REQUEST

Current Zoning: ML-2 (manufacturing and logistics)
Proposed Zoning: MUDD(CD) (mixed use development district, conditional)

Approximately 2.0 acres bound by the east side of Plymouth Avenue, south side of Dunloe Street, west side of Sylvania Avenue, and north side of North Tryon Street.

The petition proposes development of a vacant site for up to 275 multi-family residential dwelling units and minimum of 3,000 square feet and up to 8,000 square feet of non-residential space.

### EXISTING CONDITIONS

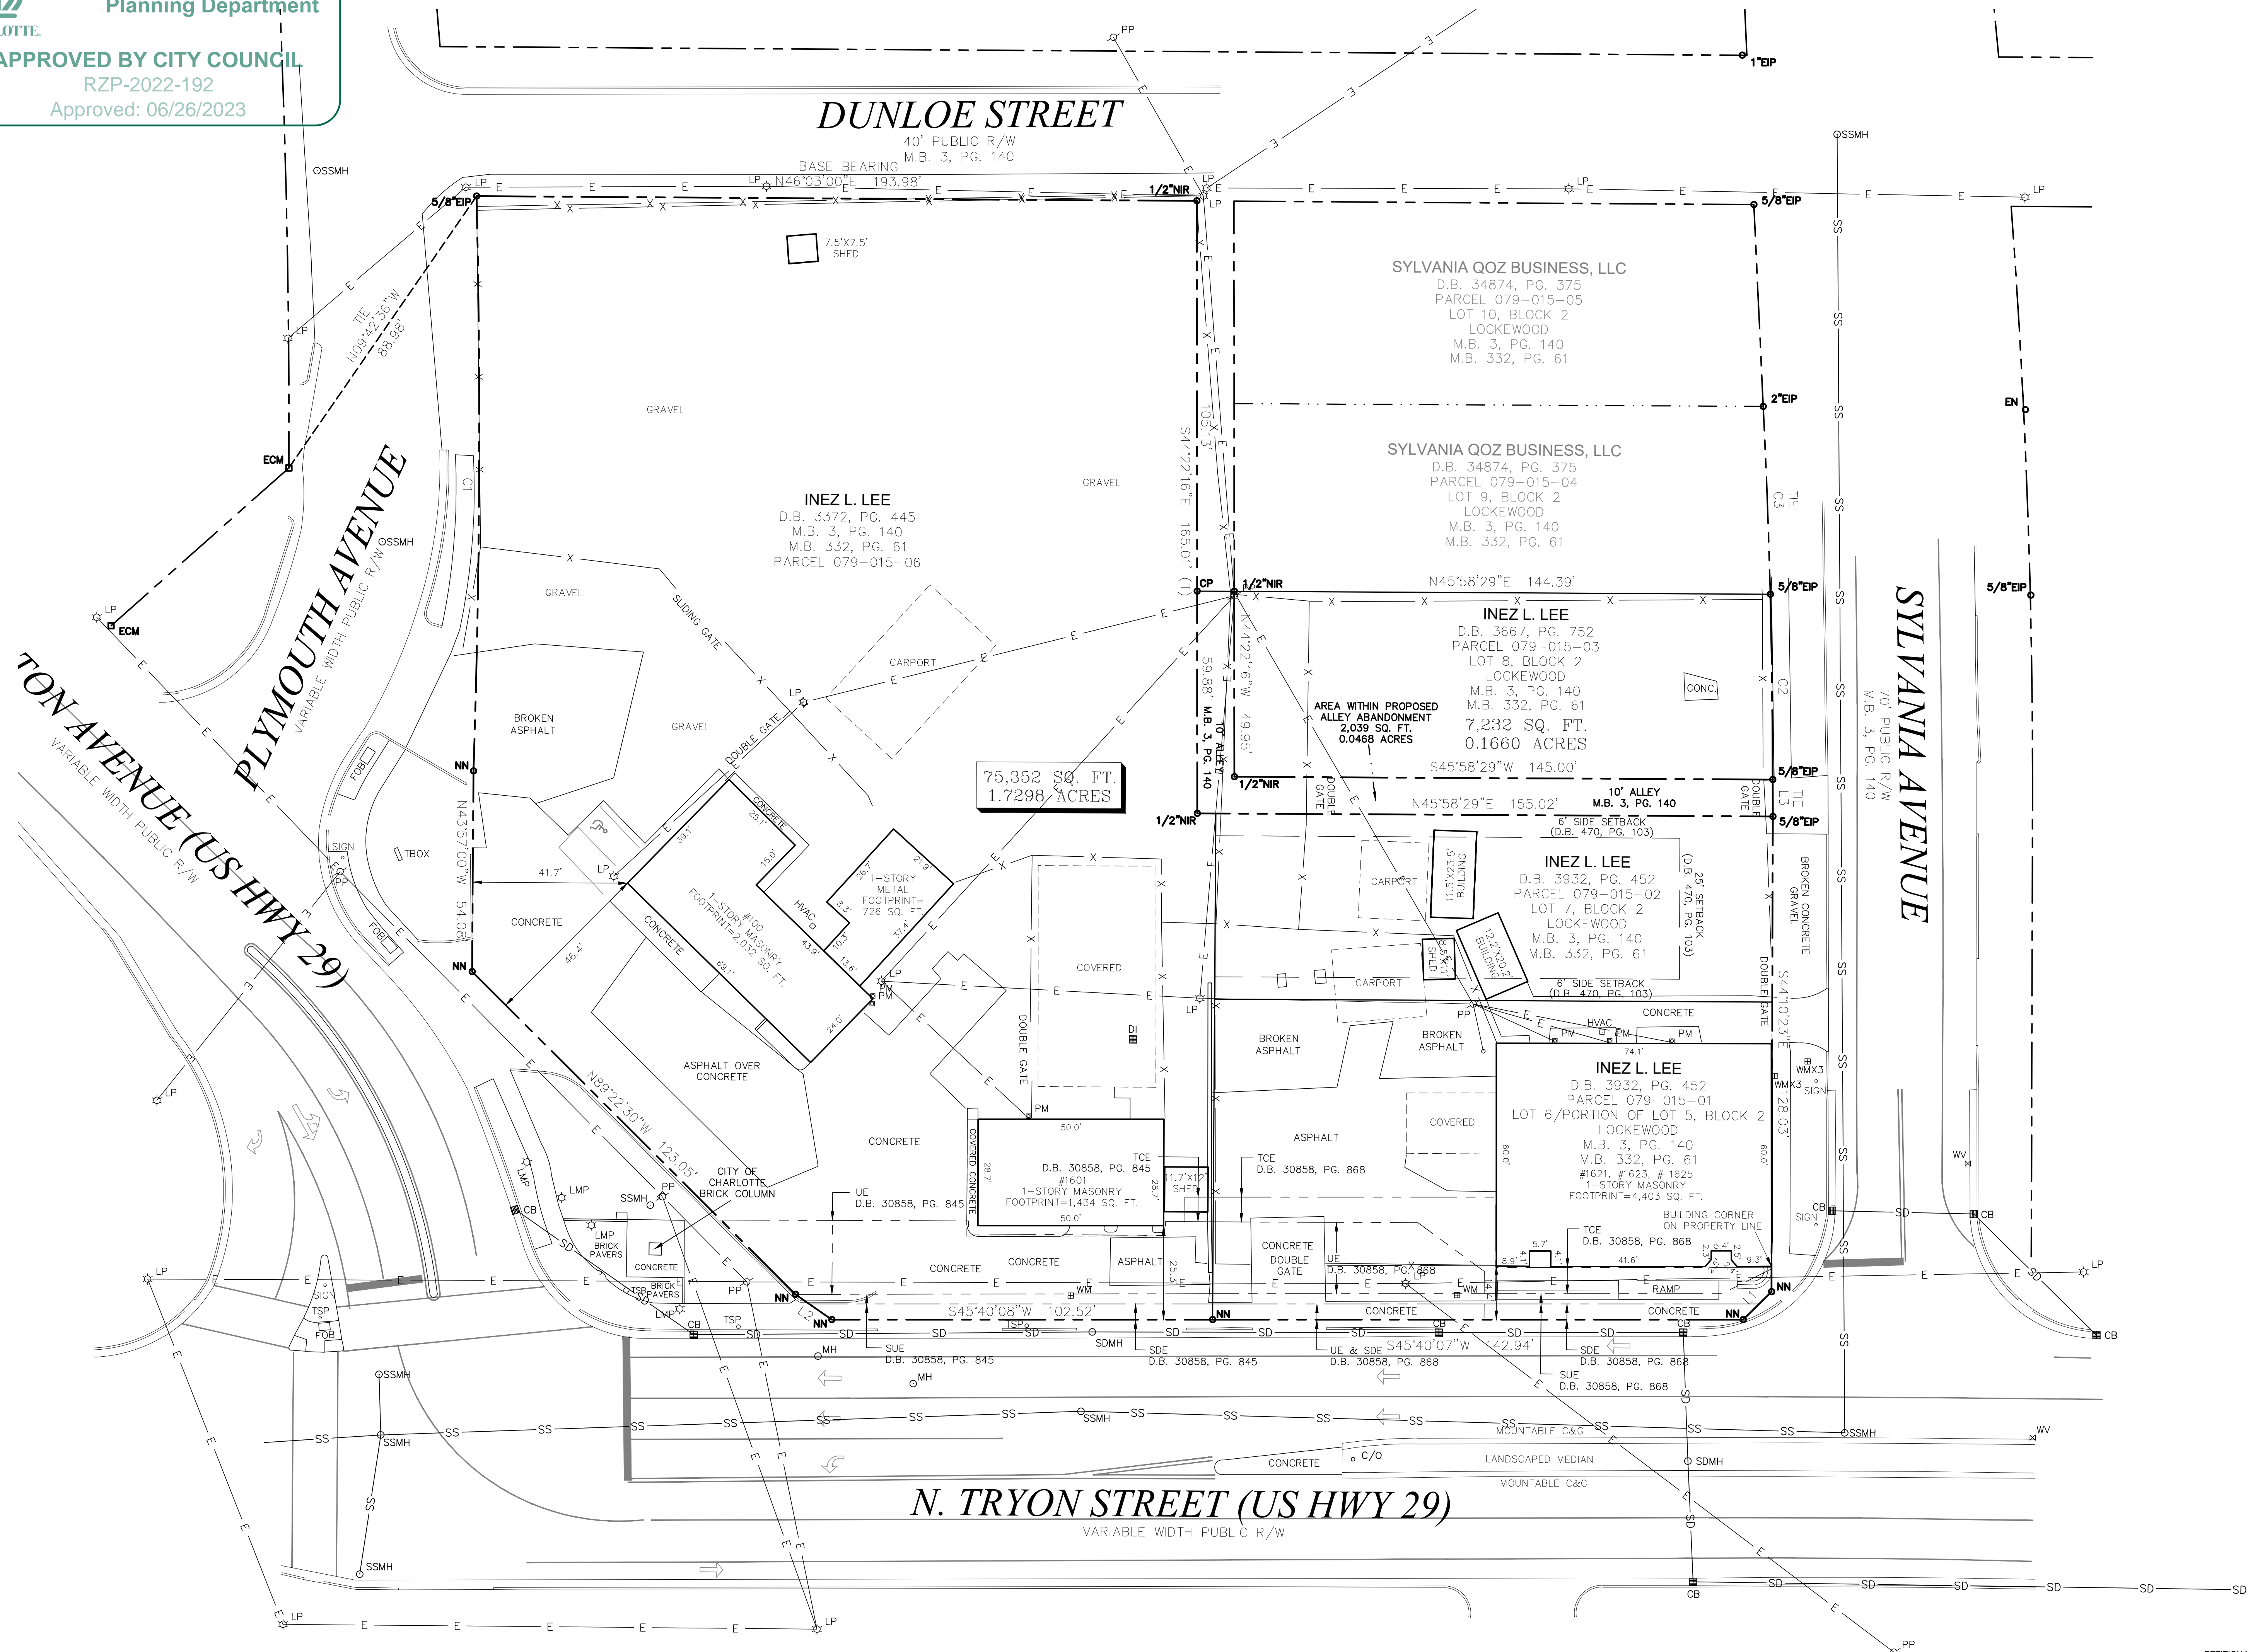
1. ~~Dalton Street: location of future curb and gutter to be moved 35 feet from roadway centerline to accommodate the Charlotte Streets Map with a roadway section of 4+ Avenue and Bike Lanes. Add conditional note that the curb line location is to be finalized during permitting in coordination with CDOT to accommodate Charlotte Streets Map.~~ Addressed
2. ~~Add a conditional note specifying "All transportation improvements will be approved and constructed before the site's first building certificate of occupancy is issued. The petitioner may phase transportation improvements if said improvements and phasing are explicitly described in site plan notes."~~ Addressed
